Florence House

**Memorandum
Department of Planning and Development
Planning Division**

RE: Avesta Housing proposal for Florence House, vicinity of 190 Valley Street

**RE: Florence House
Conditions of Approval**

A1 ROOF PLAN

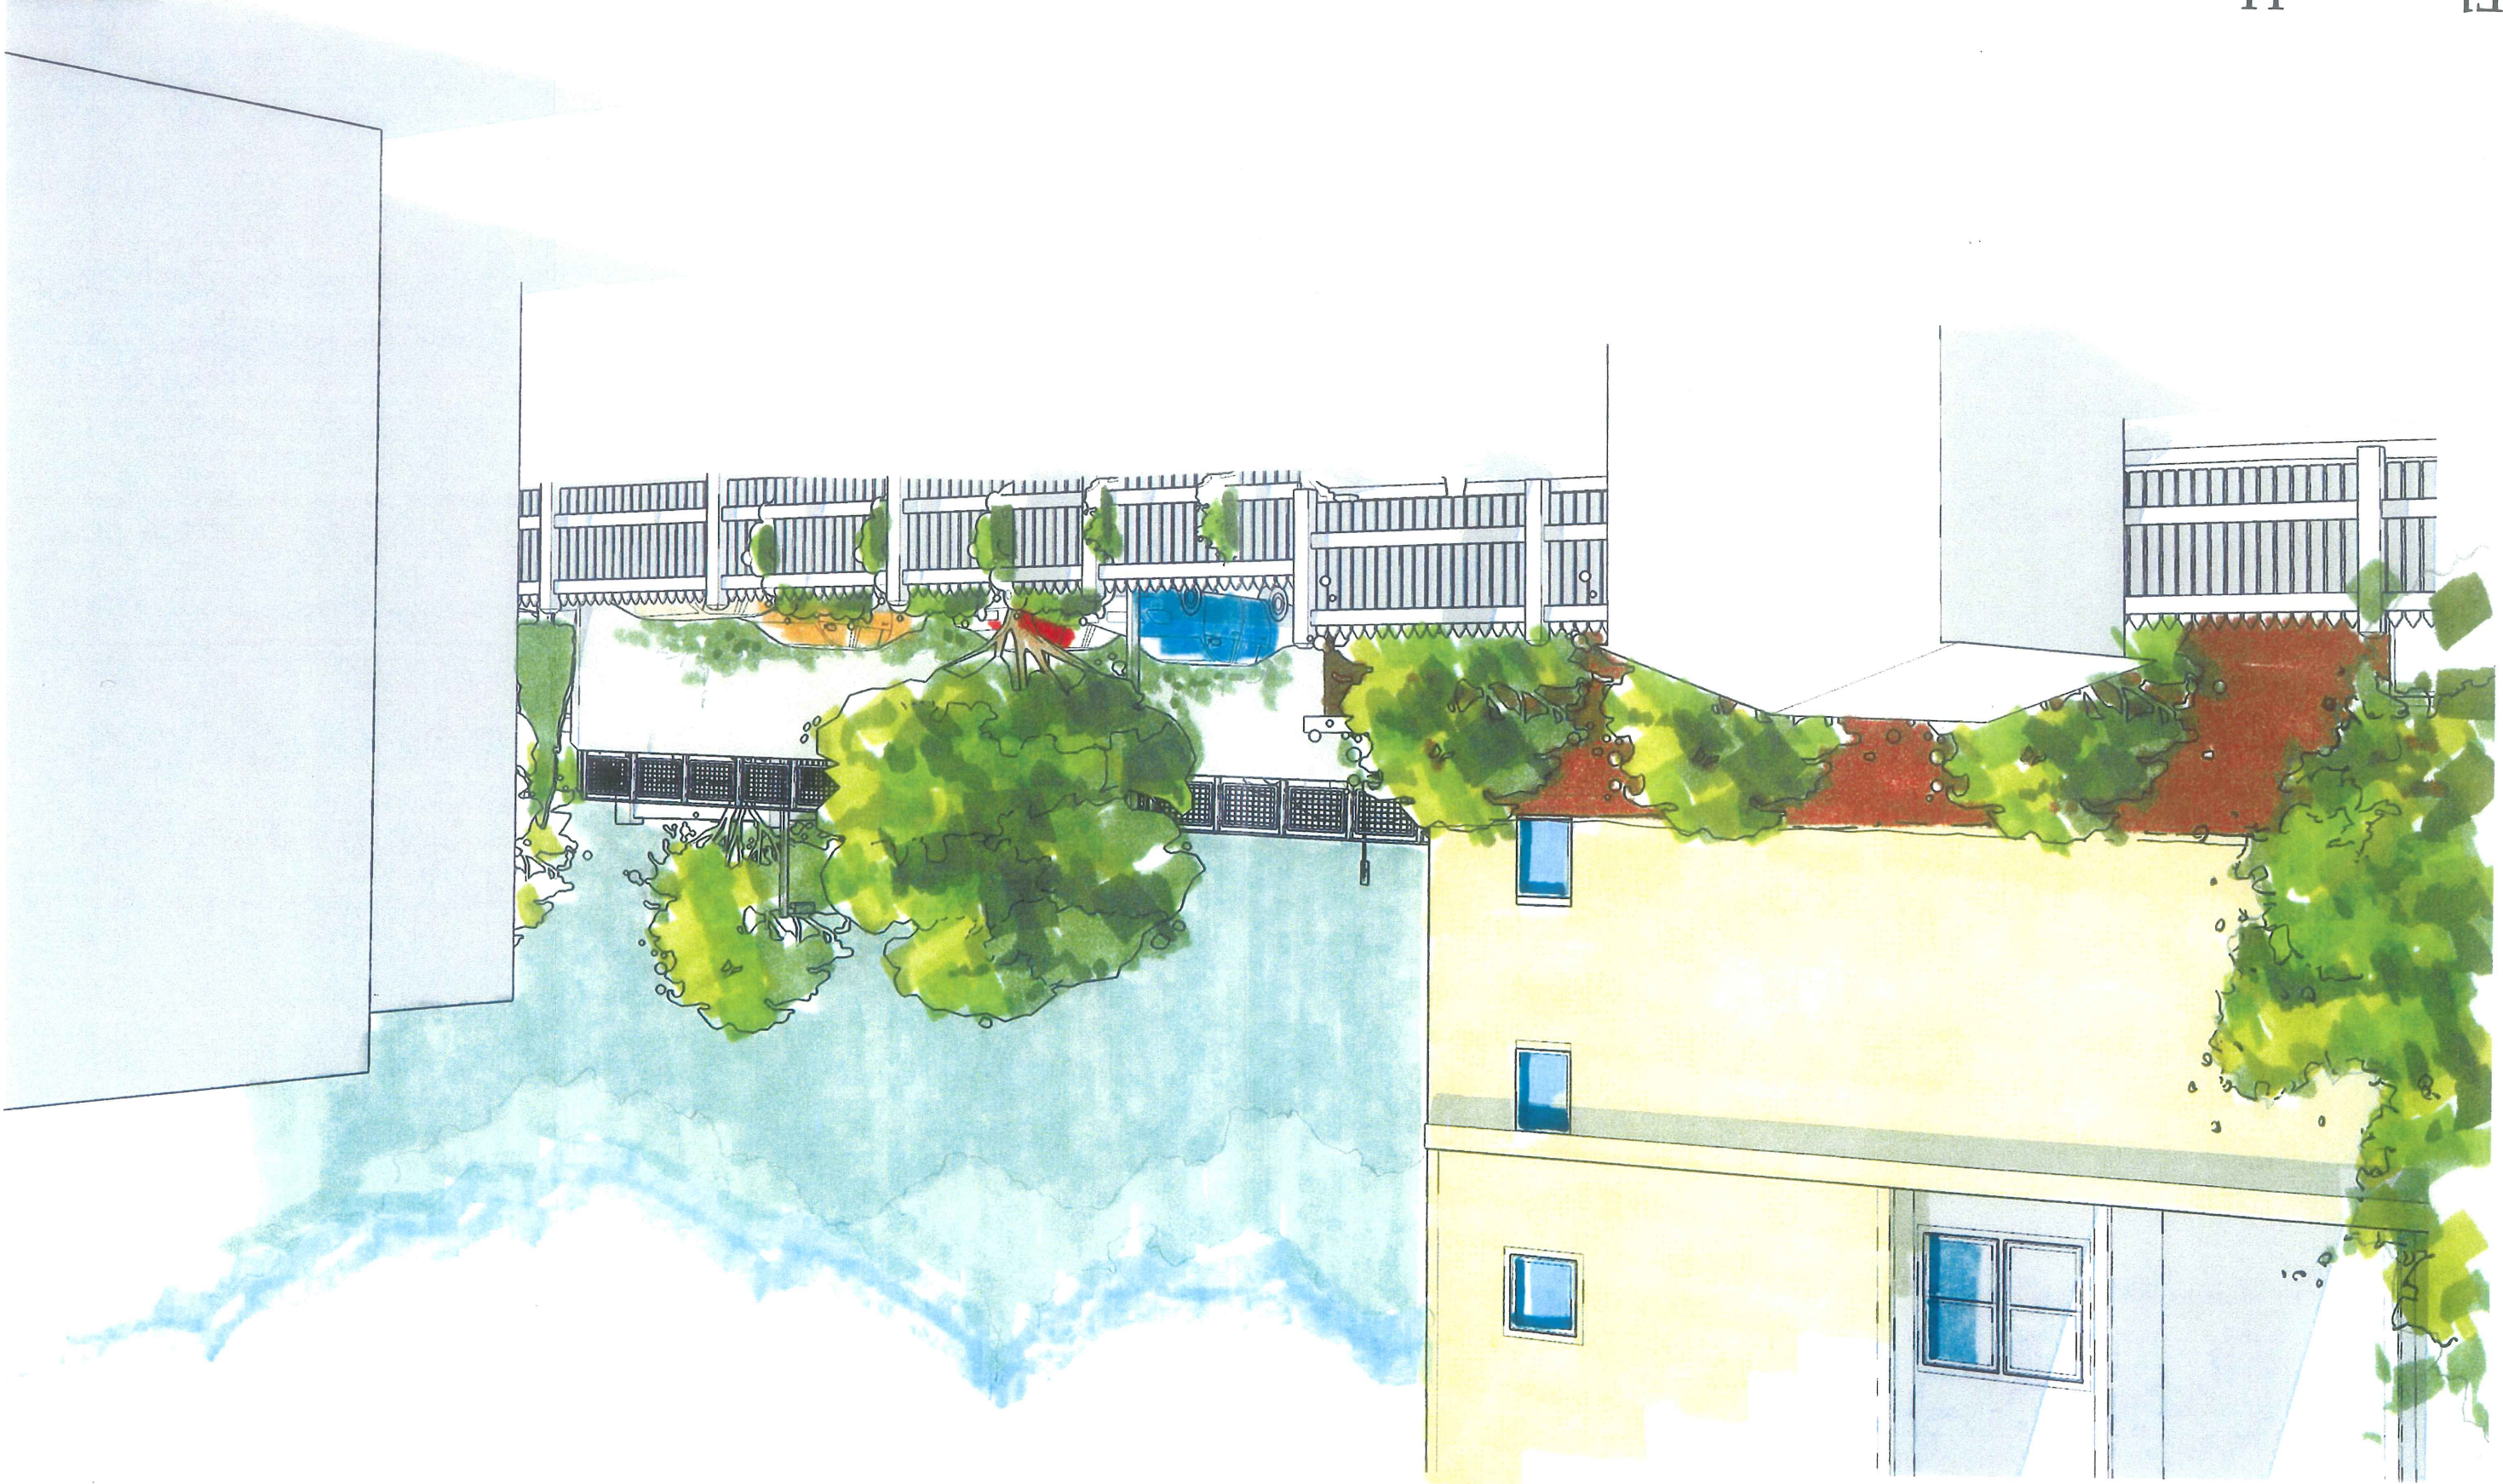
Roof. The building will have a flat roof to minimize its height. The screening of the rooftop mechanicals is critical, particularly given the proximity to the Western Prom. The design and specifications of the screened area that will hide the rooftop mechanicals should be provided.

Roof. The design and specifications of the screened area that will hide the rooftop mechanicals should be provided.

Please submit specs for the roof plant screening and for the elevator hoist way vent.

- Please see attached rooftop mechanical equipment screen specifications and cut-sheets and elevator hoist way vent cut-sheet. A sample of the metal used for the equipment screen has also been submitted.

**A1 LANDSCAPE AND PLANTING PLAN**

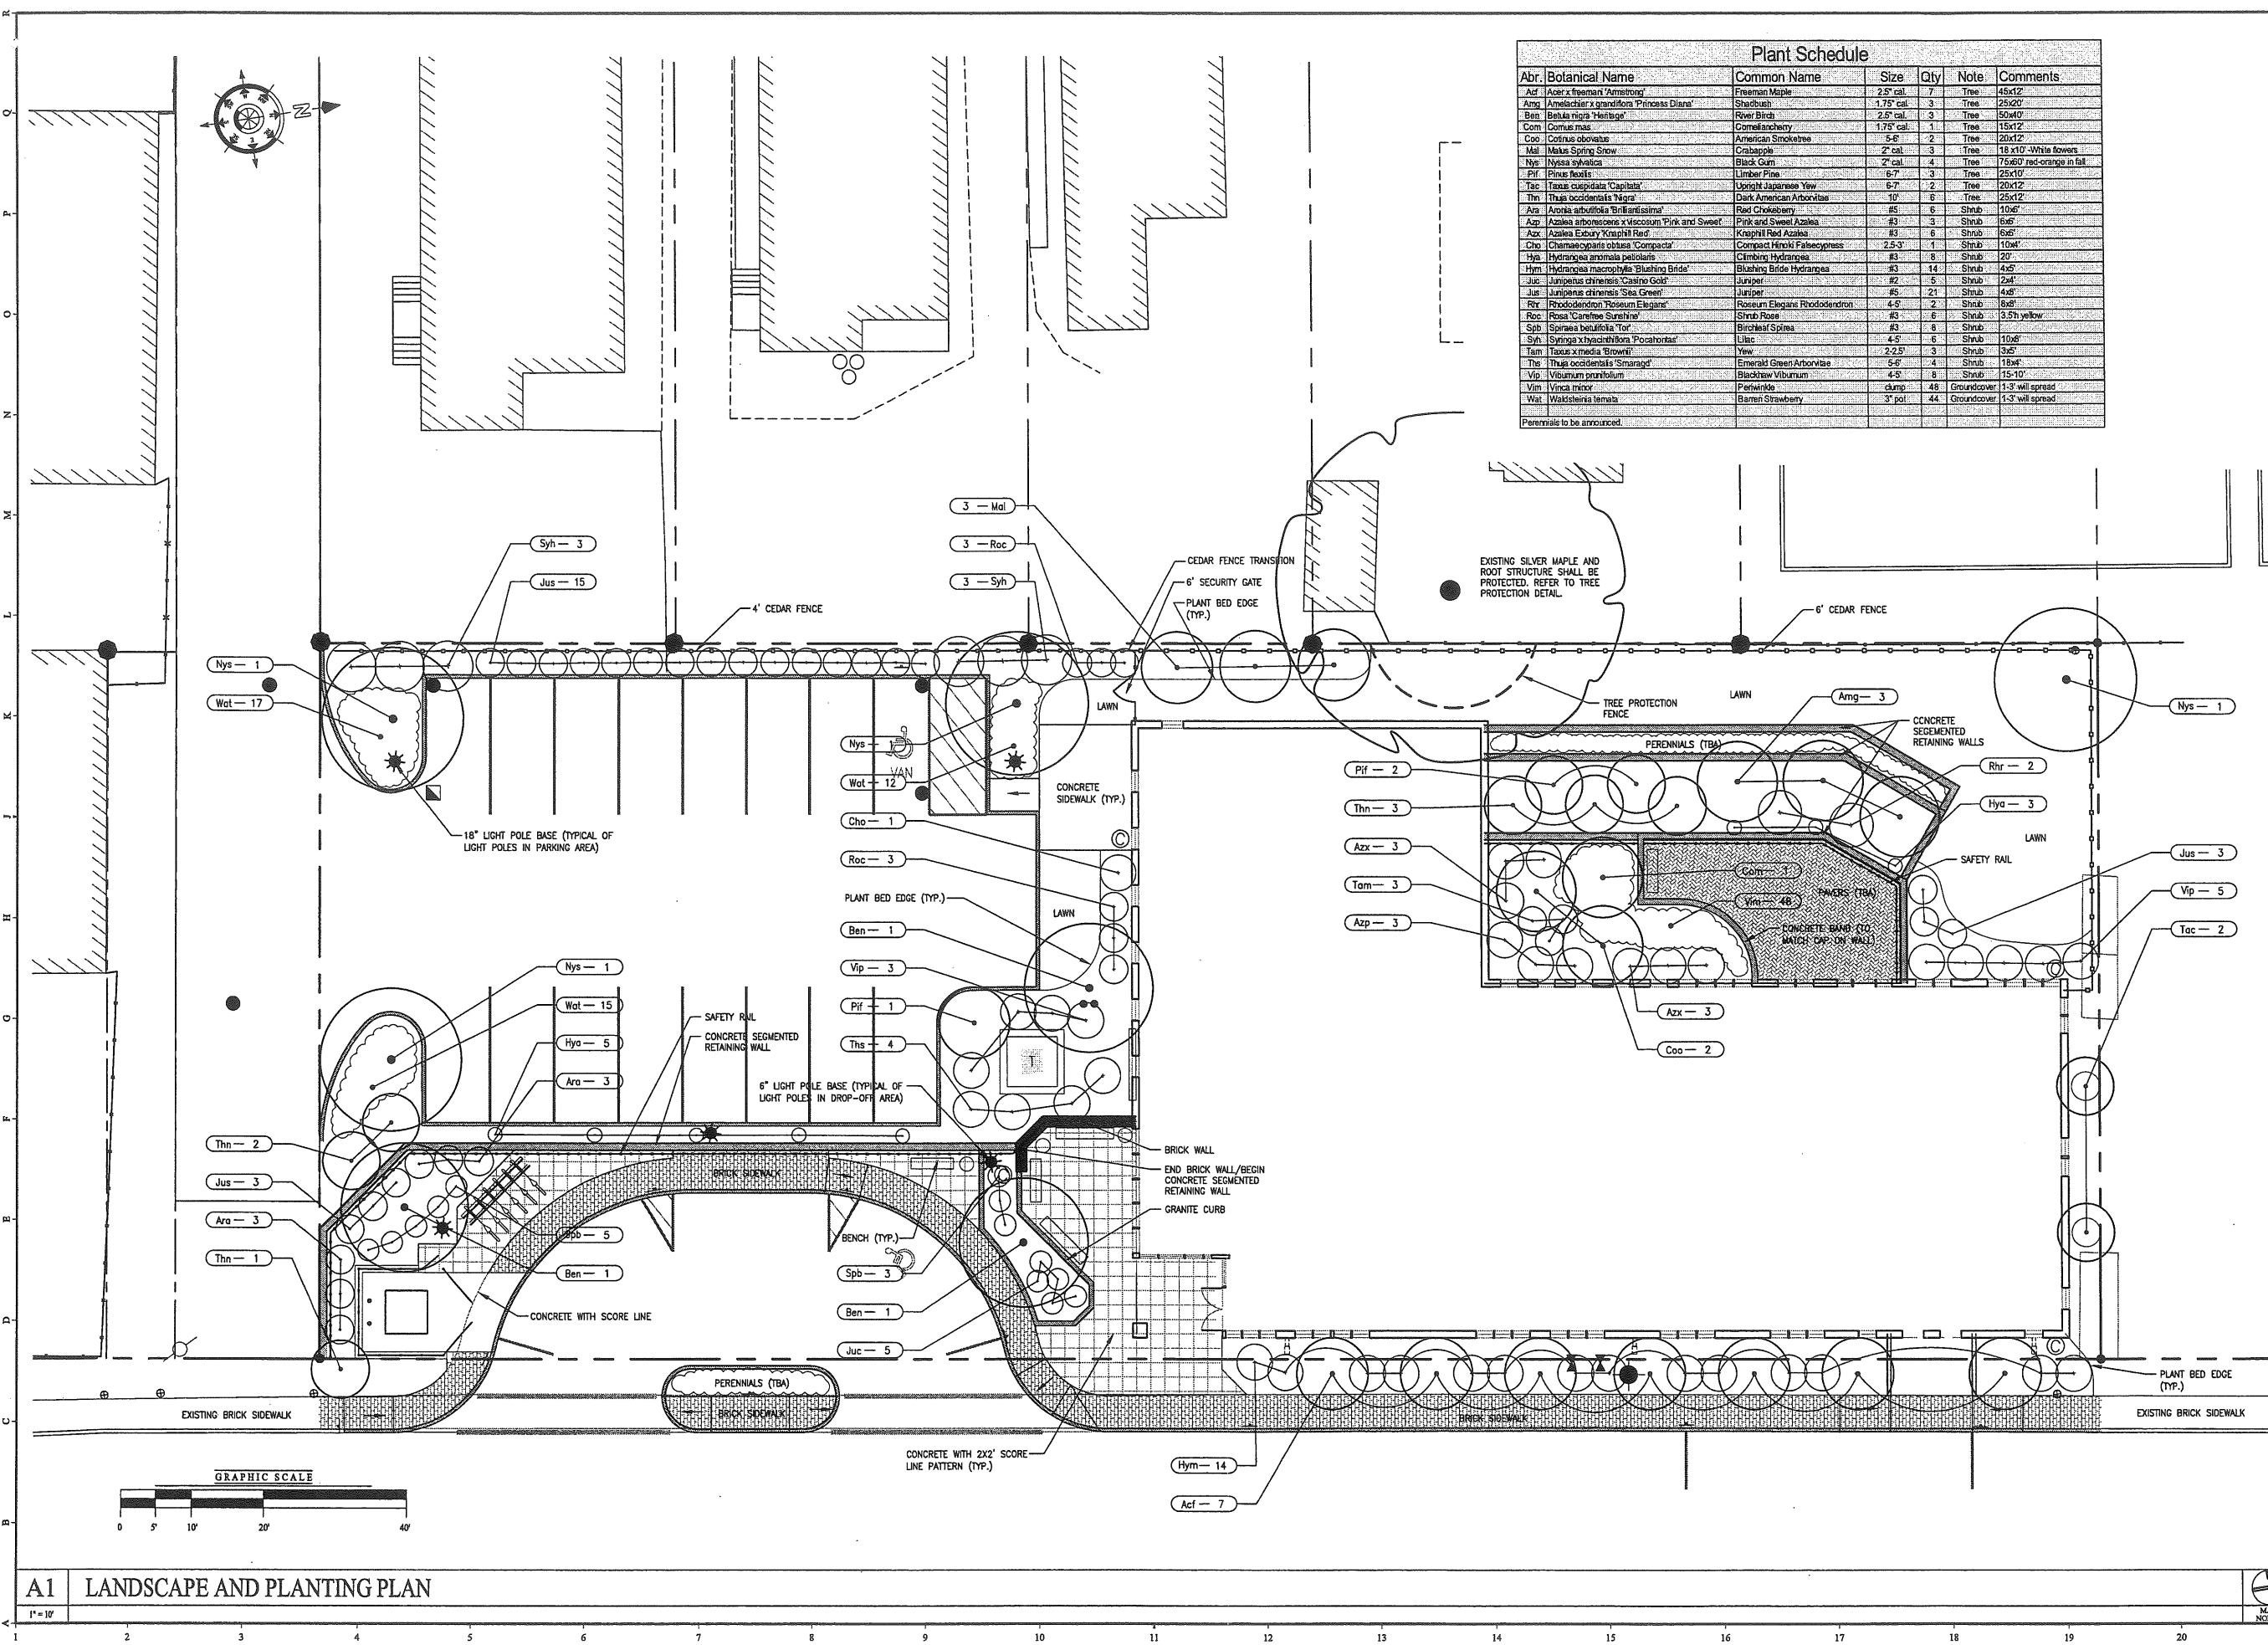
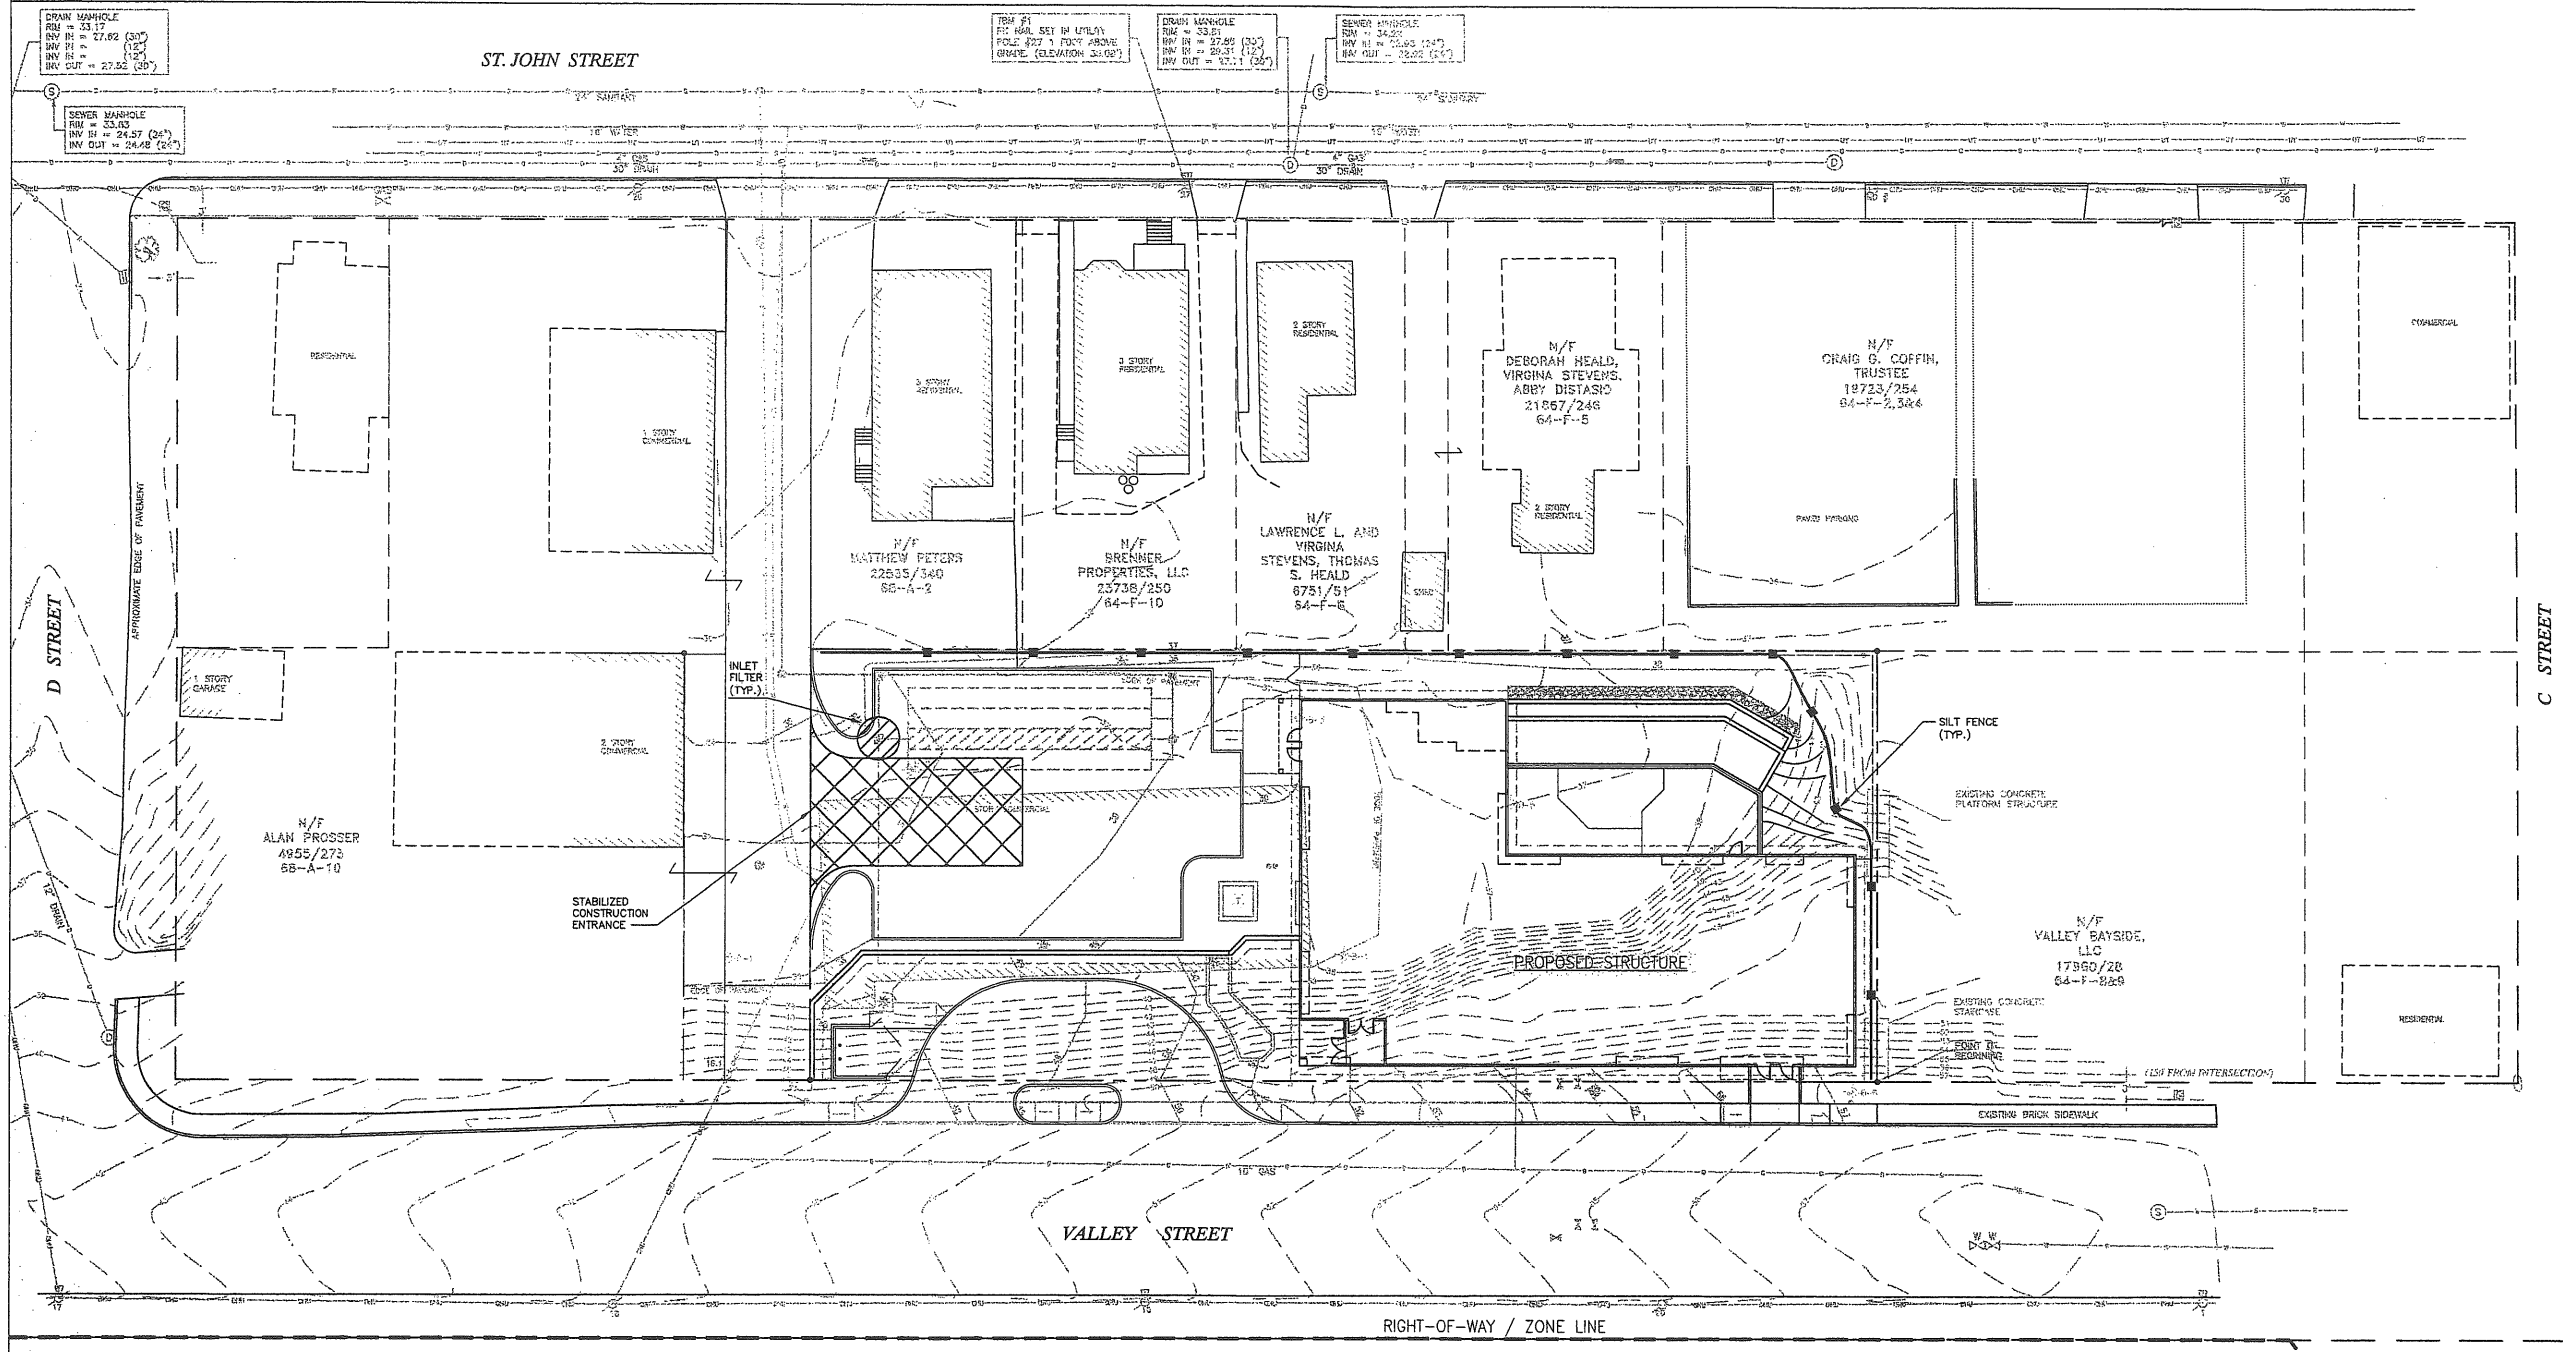
We note there have been a number of changes to the number and choice of plants, including to those outlined in the letter of Oct 2, 2007 and described to the Planning Board. These revisions require review and I will get back to you once I have final comments.

- Revisions to plant material are based on MaineHousing standards which require at least 75% northern hardy native species; which is measured by the number of plantings. The plan approved by the Planning Board included 34 trees, 101 shrubs, 92 groundcover plants and an unspecified number of perennials. The plan submitted to you on August 12, 2008 increases the quantity of plant material and includes 37 trees, 170 shrubs, 116 groundcover plants and 58 perennials; 82.4% of which are northern hardy native species.
